**Re: Lot 18 DP 270644, Greystanes Southern Employment Land (Boral Land)
Section 96 Application SSD_6801**

We provide this letter relating to a proposed Section 96 application to the Greystanes Southern Quarry West project approved under SSD_6801. Specifically this letter covers the civil engineering aspects of the amendment.

The Section 96 Application is for an amendment to the approved layout defined in SSD_6801. The main component of the amendment is for an adjustment to the approved masterplan lot layout and minor changes to warehouse levels in Precincts A and B.

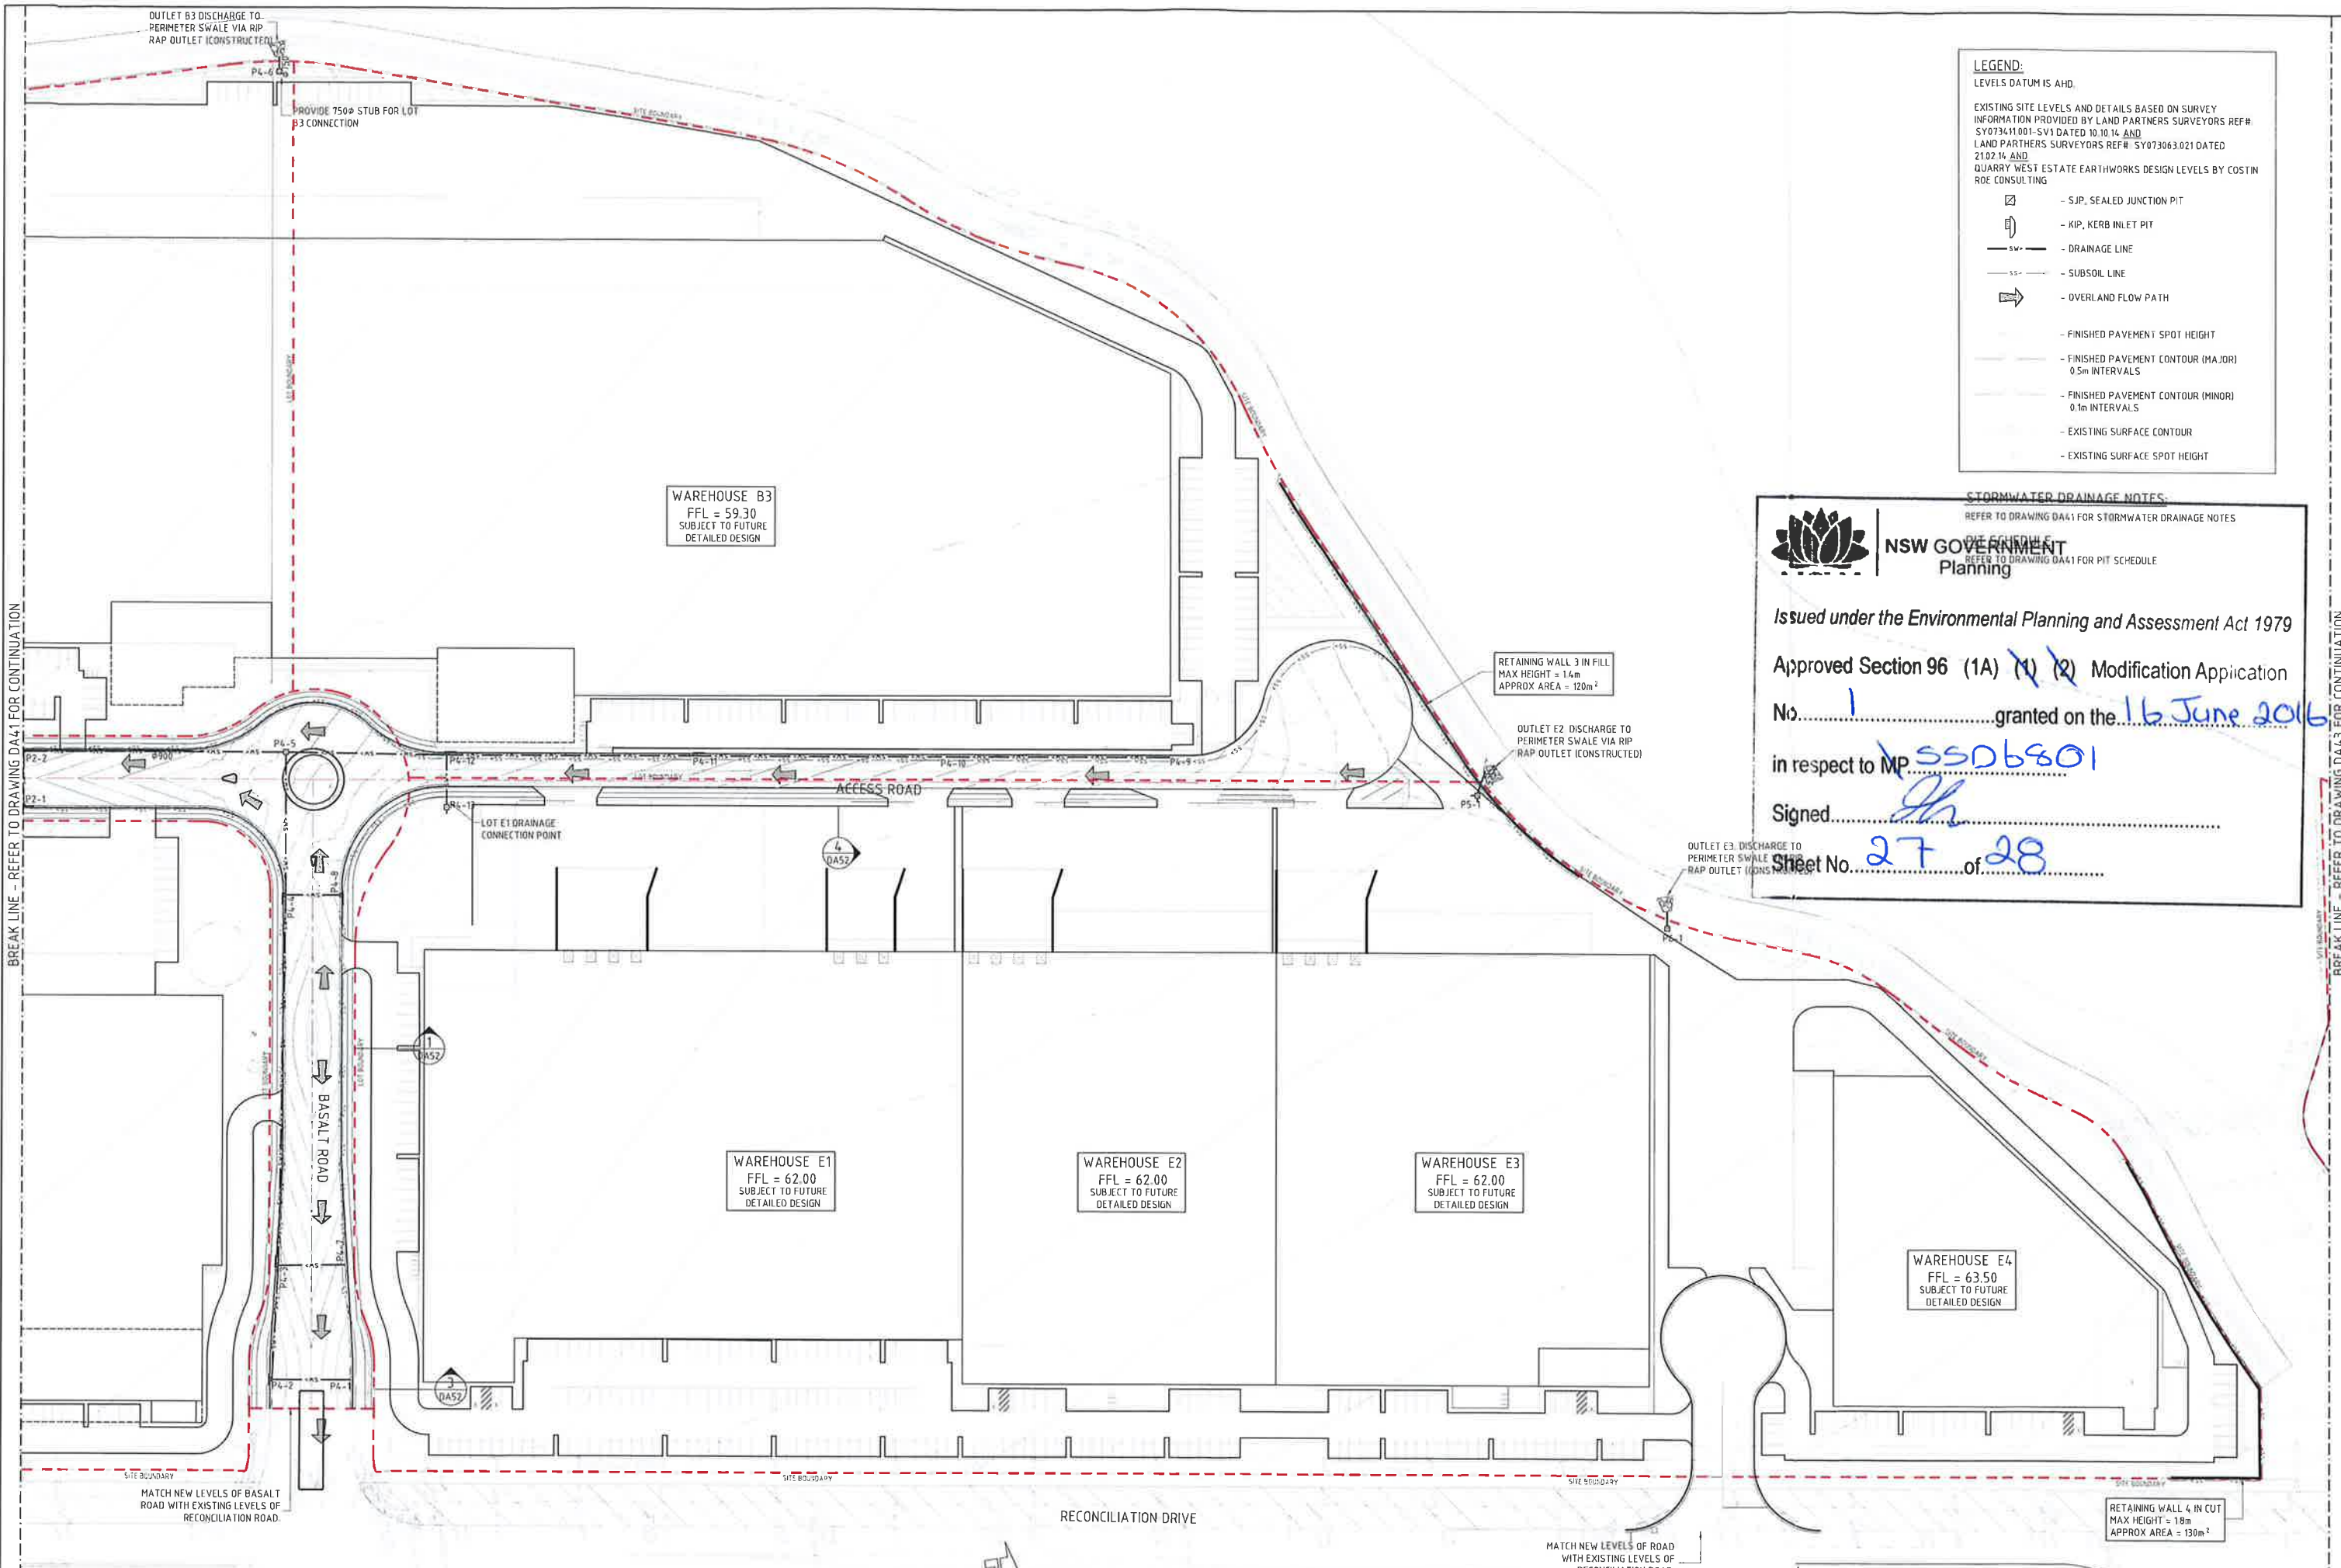
The development layout differs from the previous submission in that the arrangement of the development lots on the northern side of Dolorite Close within Precincts A and B have been adjusted.

The adjustments mainly relate to Warehouse B1 and Warehouse A2. The lot layouts to the east and south of the estate road are generally consistent with the approved SSD_6801. Some minor changes to car park arrangement to the north of Warehouse B2 have also been made.

The floor levels for warehouse B1 and B2 have had some minor adjustments to suit a balance of cut to fill earthworks and to better facilitate access to the development sites.

Warehouse B1 floor level has been lowered from 59.3 to 59.00m while Warehouse B2 has been raised from 59.30 to 59.90m.

C010529.34-DA46

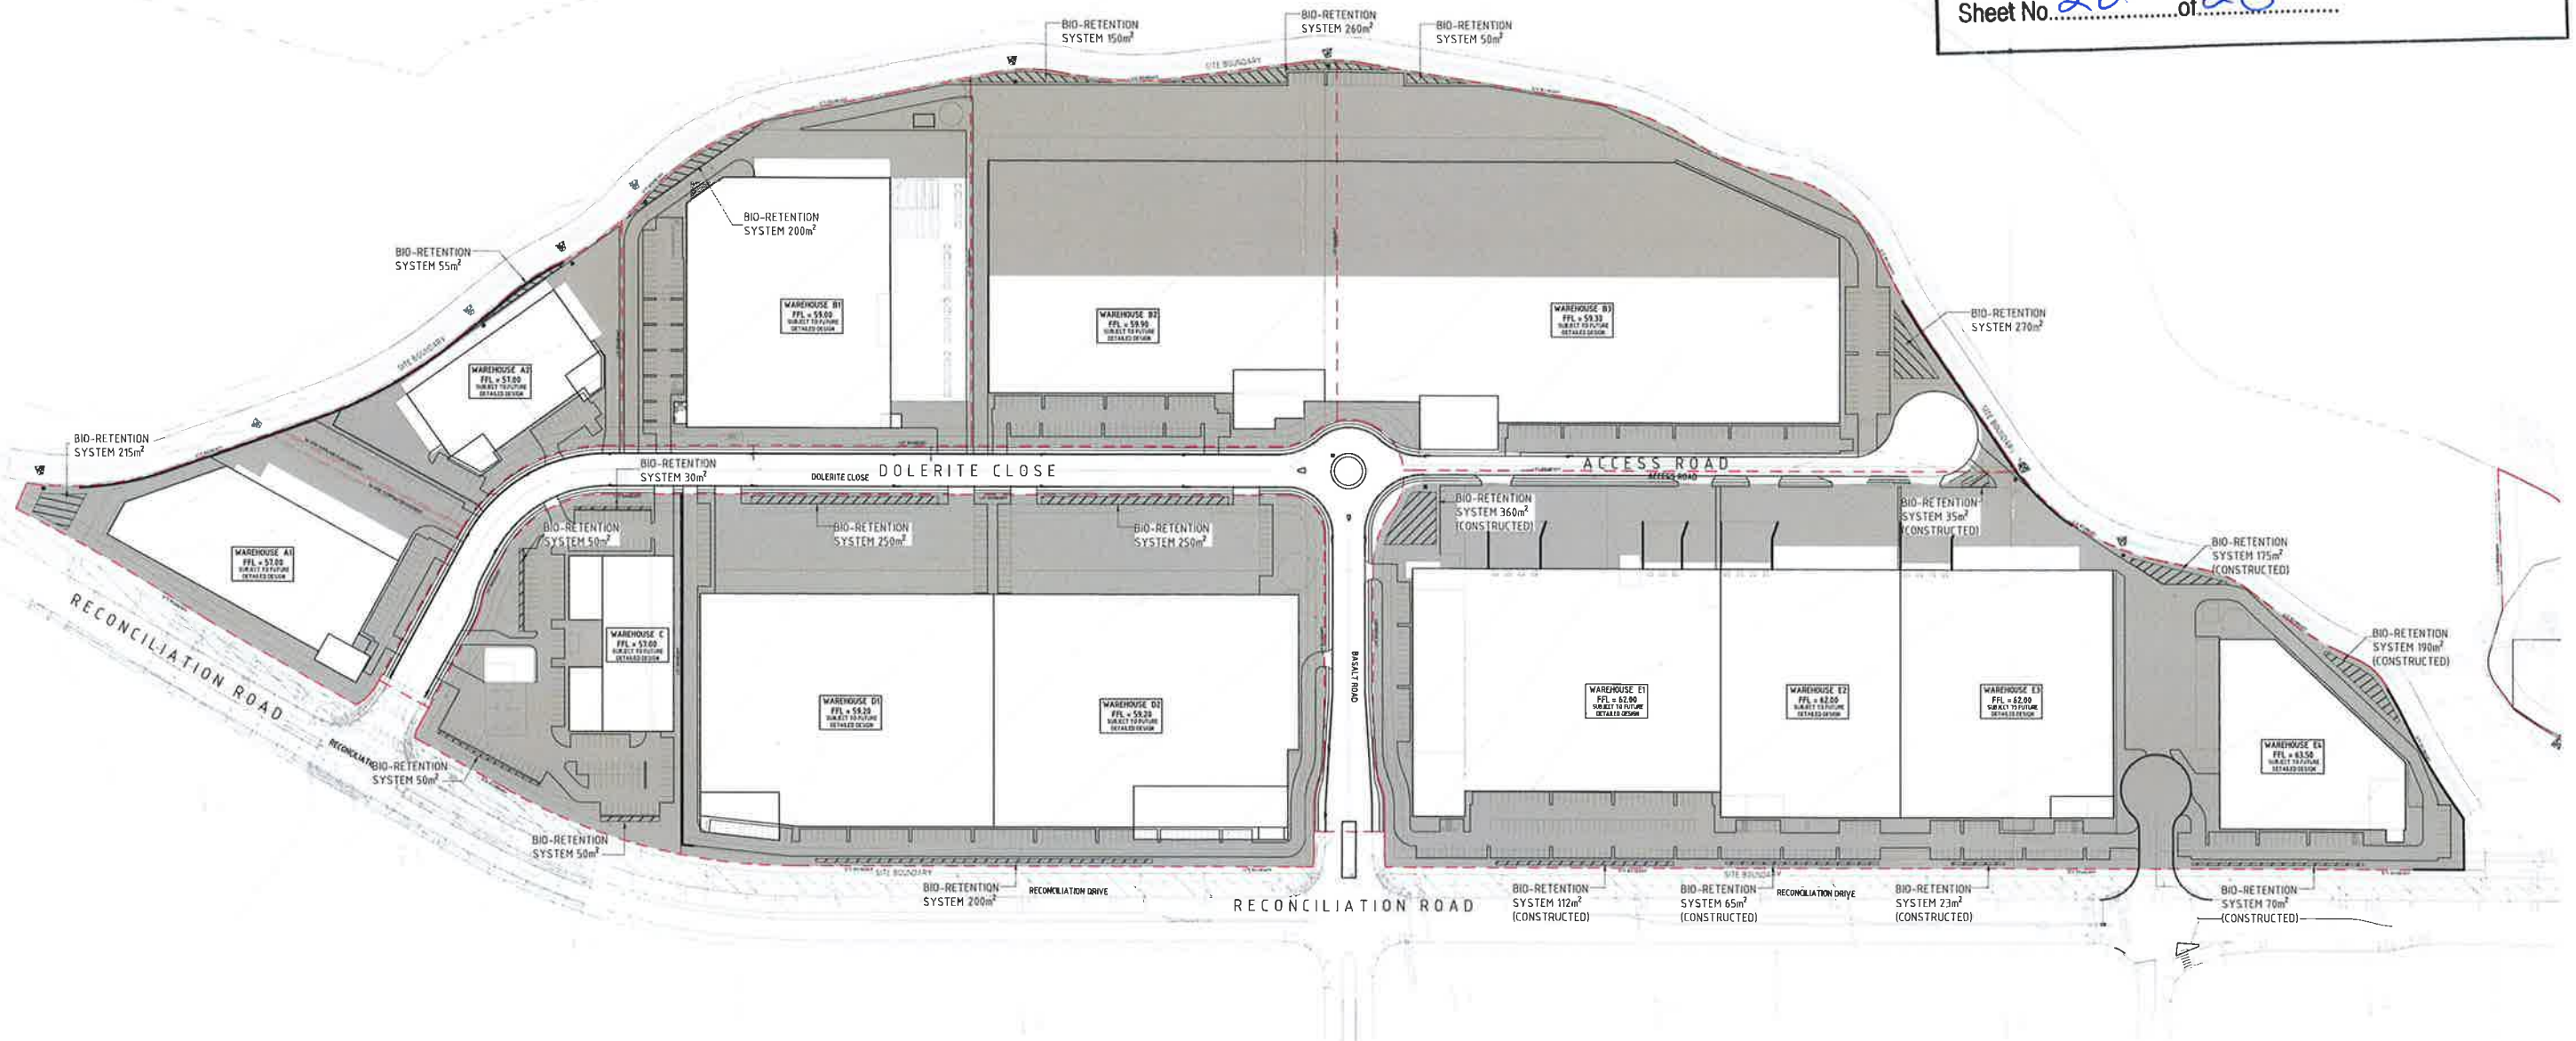
Minor adjustments to the locations of the bio-retentions within the site have been made. The basin to the north of Warehouse B2 & Warehouse B3 has been adjusted as a result of the carpark arrangement specified above. It can be confirmed that the minimum required 3000m² of bio retention, as defined in SSD_6801, has been provided.

Additionally an extra stormwater outlet pipe and stub has been provided to the north of Warehouse B1. This is the result of the adjusted development layout and boundary location specified above. The majority of the approved drainage outlets have now been constructed, therefore an additional outlet pipe is required to facilitate drainage of Warehouse B1 without the need for easements within adjoining lots. This change does not affect the ability for the western drainage swale to convey the required 1 in 100 year ARI design storm.
